RE: ALBUQUERQUE WEST PET RESORT, CITY PROJECT NO. 5104.80 MAP NO. C-12

RE: GRADING & DRAINAGE PLAN FOR ALBUQ WEST PET RESORT (C-12/D3B3)
RECEIVED APRIL 3, 1996 FOR S DEV PLAN, FINAL PLAT & BUILDING PERMIT
ENGINEER'S STAMP DATED 02-22-96

**Re: Marna Lynn Townhomes Grading and Drainage Plan
Engineer's Stamp dated 2-3-06 (C12/D3B3)**

Re: Marna Lynn Ave Townhomes, Marna Lynn Avenue
Grading and Drainage Plan
Engineer's Stamp dated 11-17-05 (C12-D3B3)

GRADING & DRAINAGE
PLAN

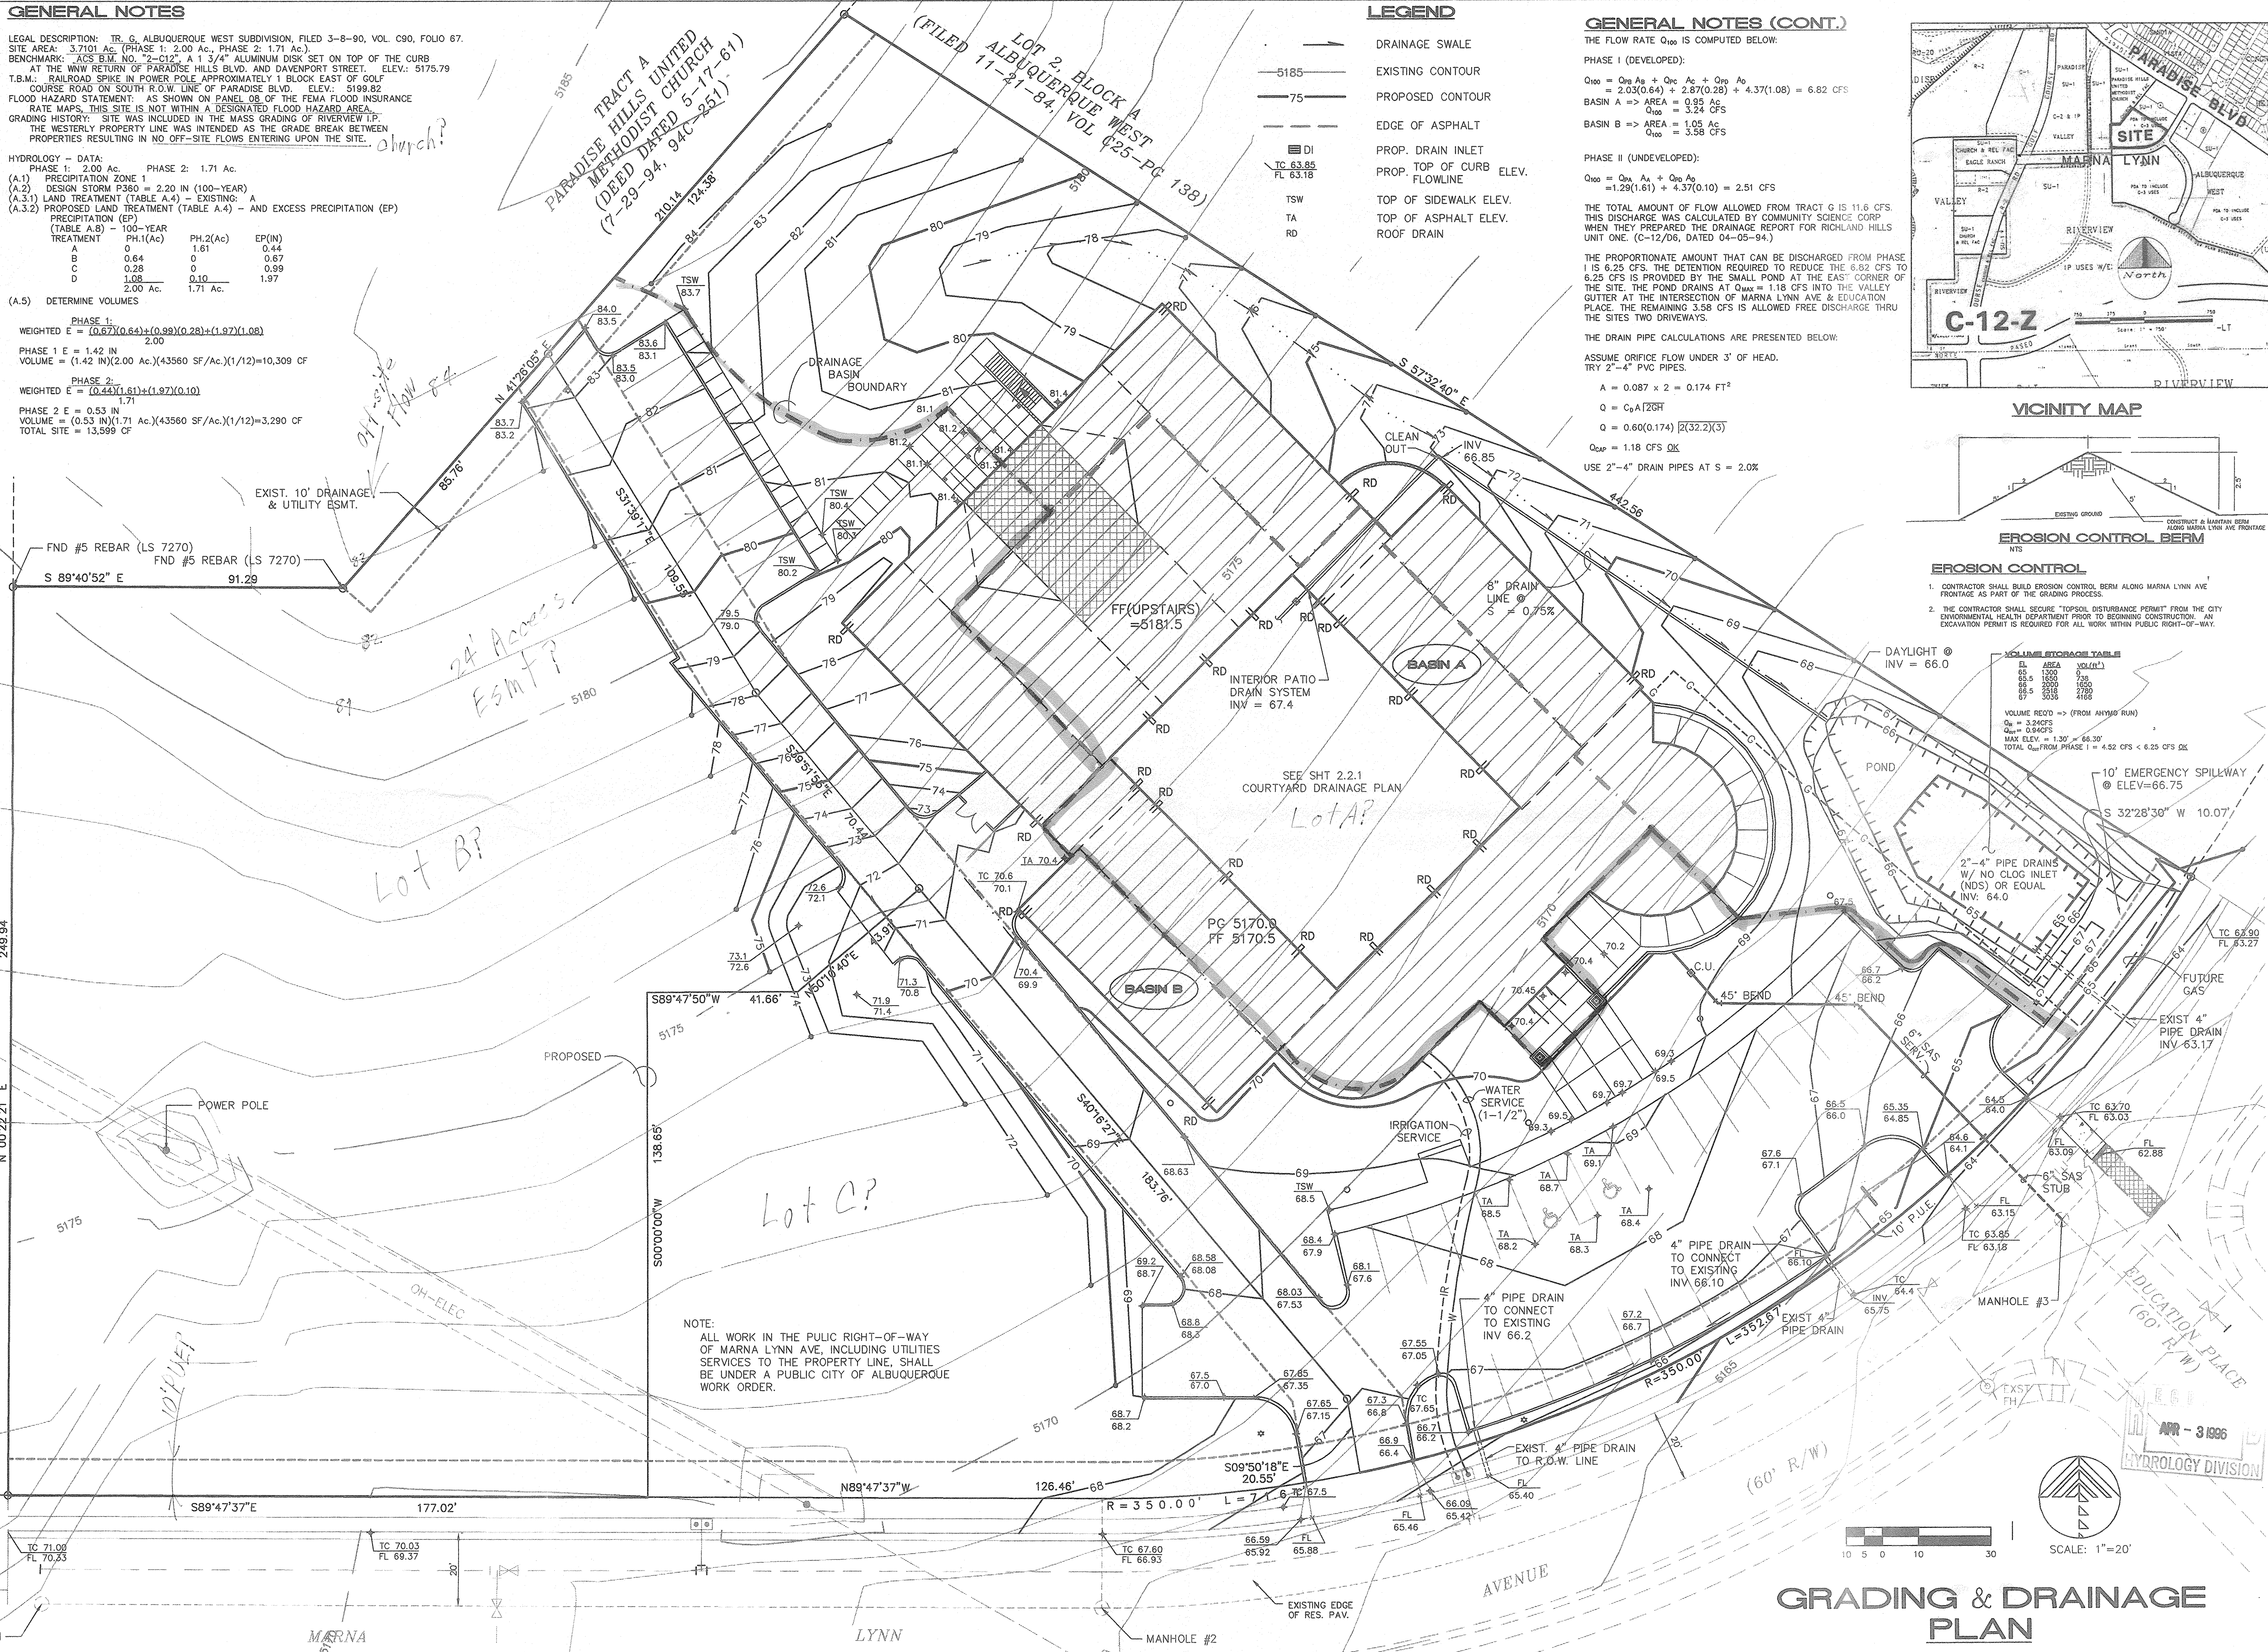
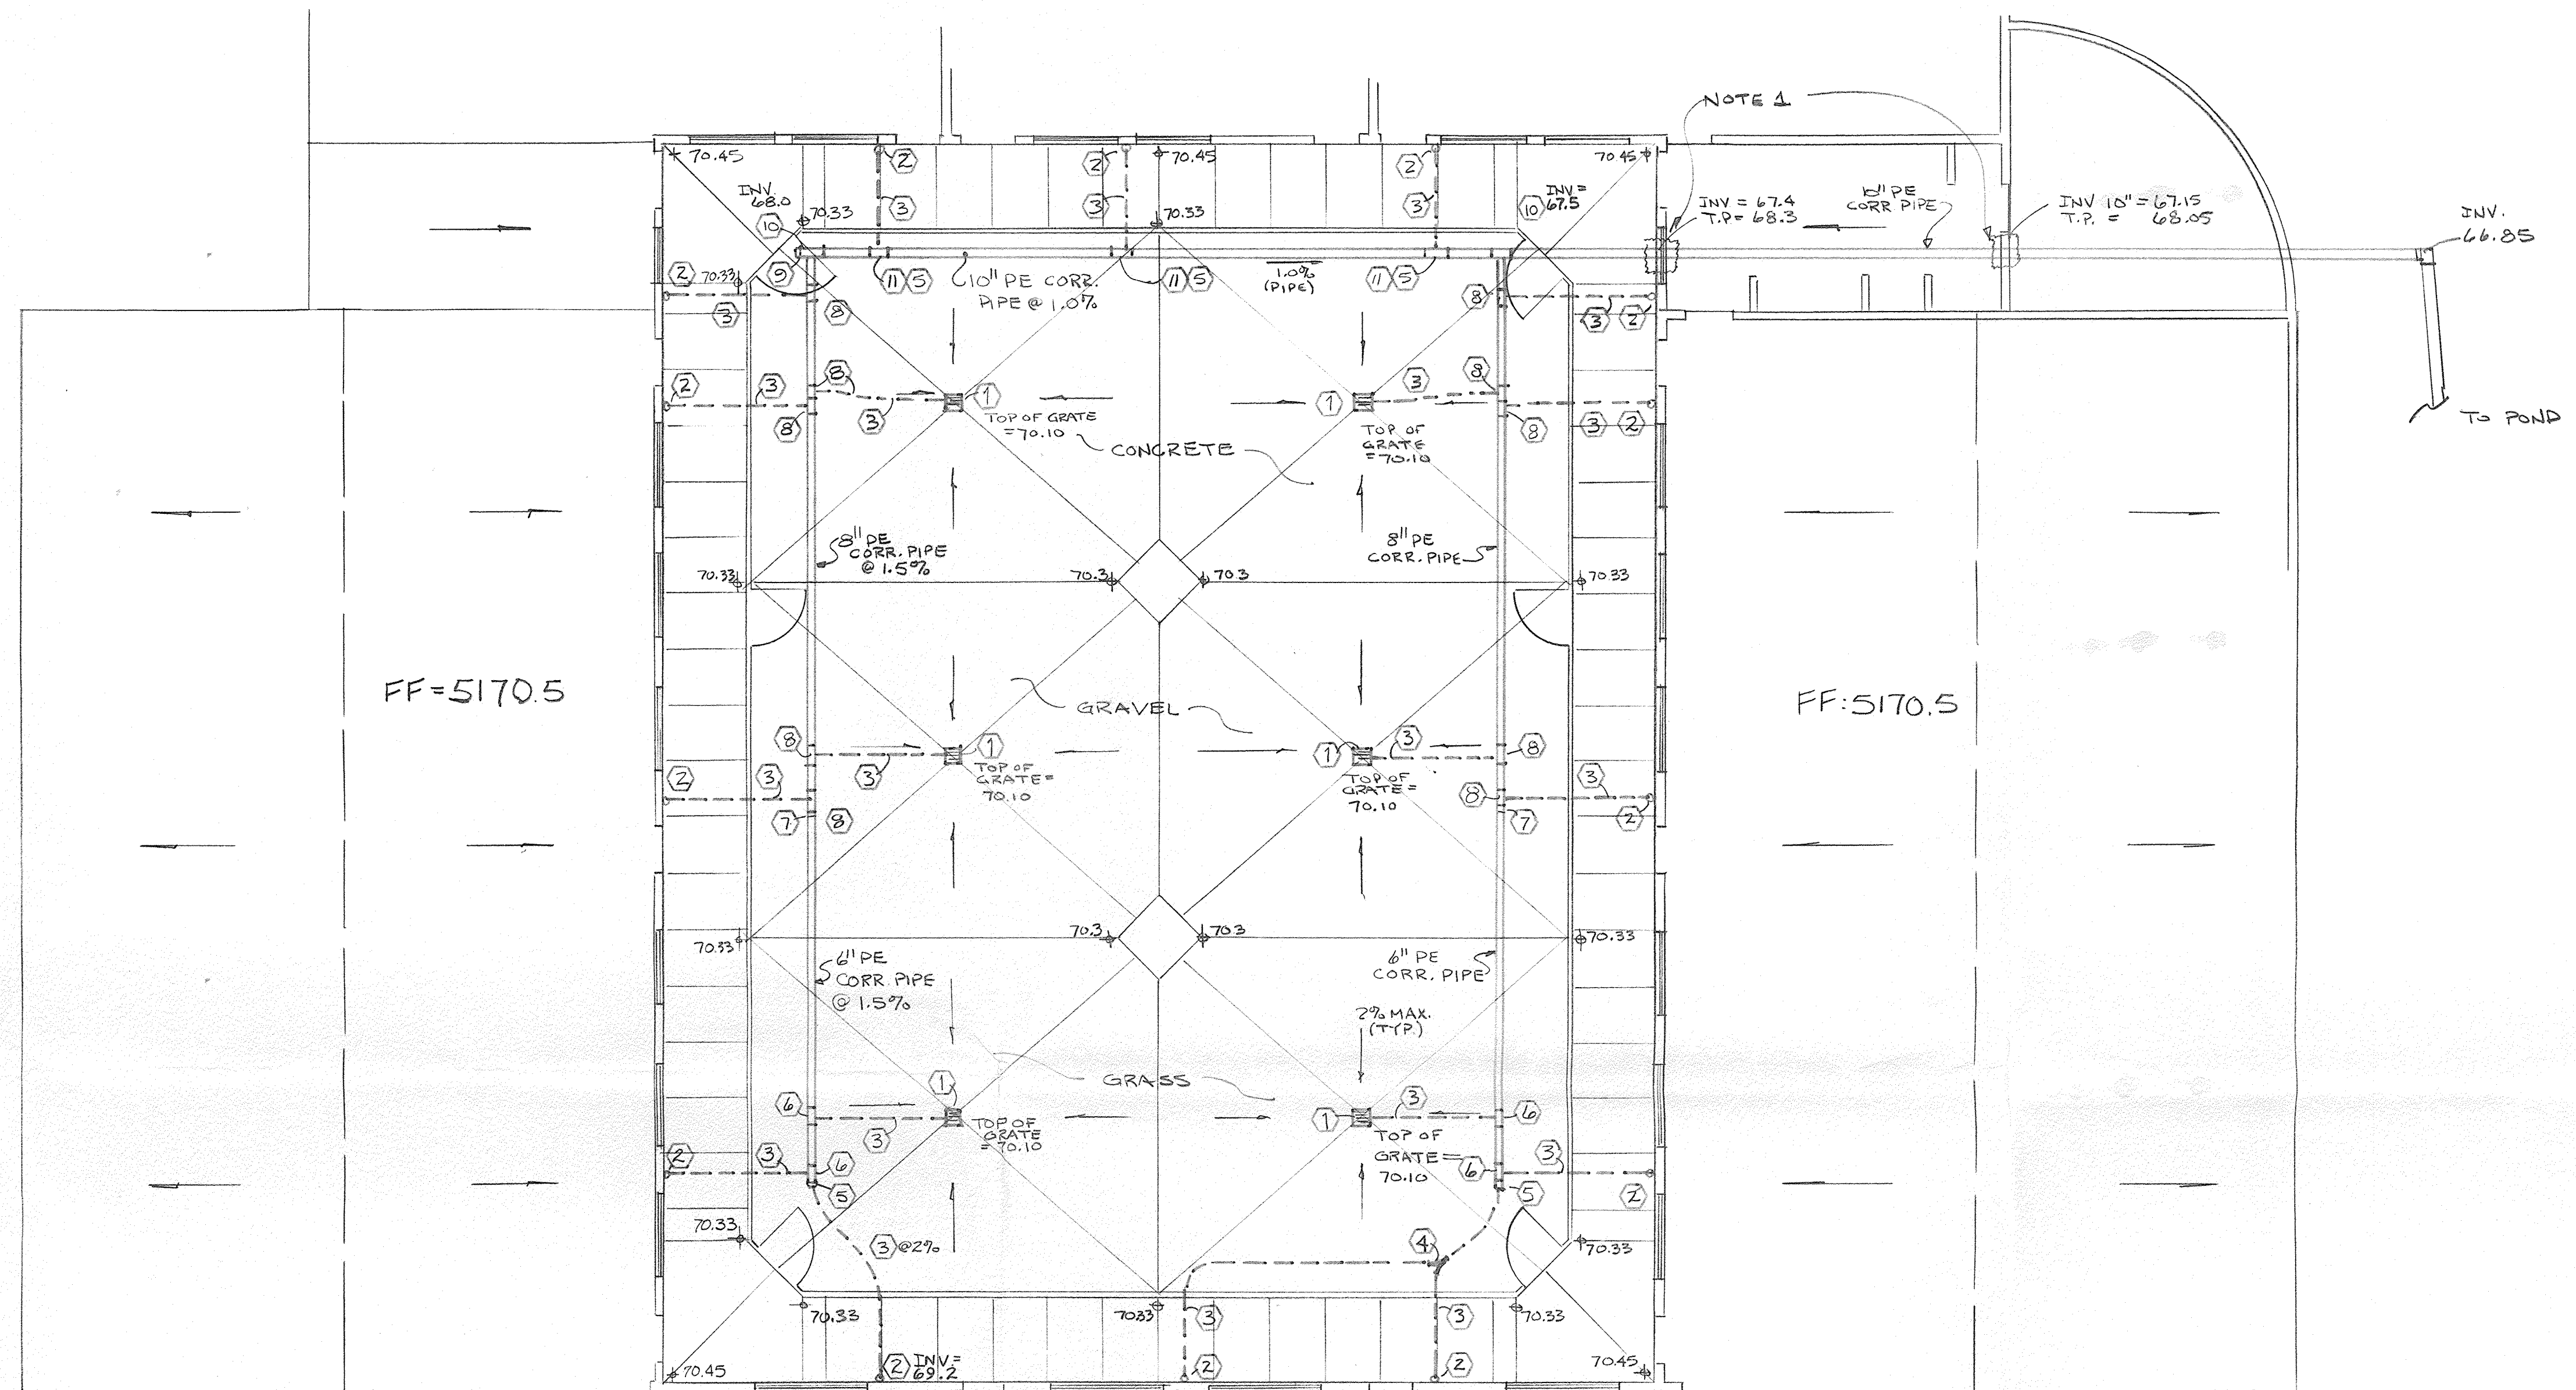
The following comments must be addressed before the Grading & Drainage Plan will be accepted for Final Plat: It appears that off site flow from the Church enters Phase 2. Address the impact on the site. Label each of the three lots and all easements. Identify the allowable discharge for each lot.
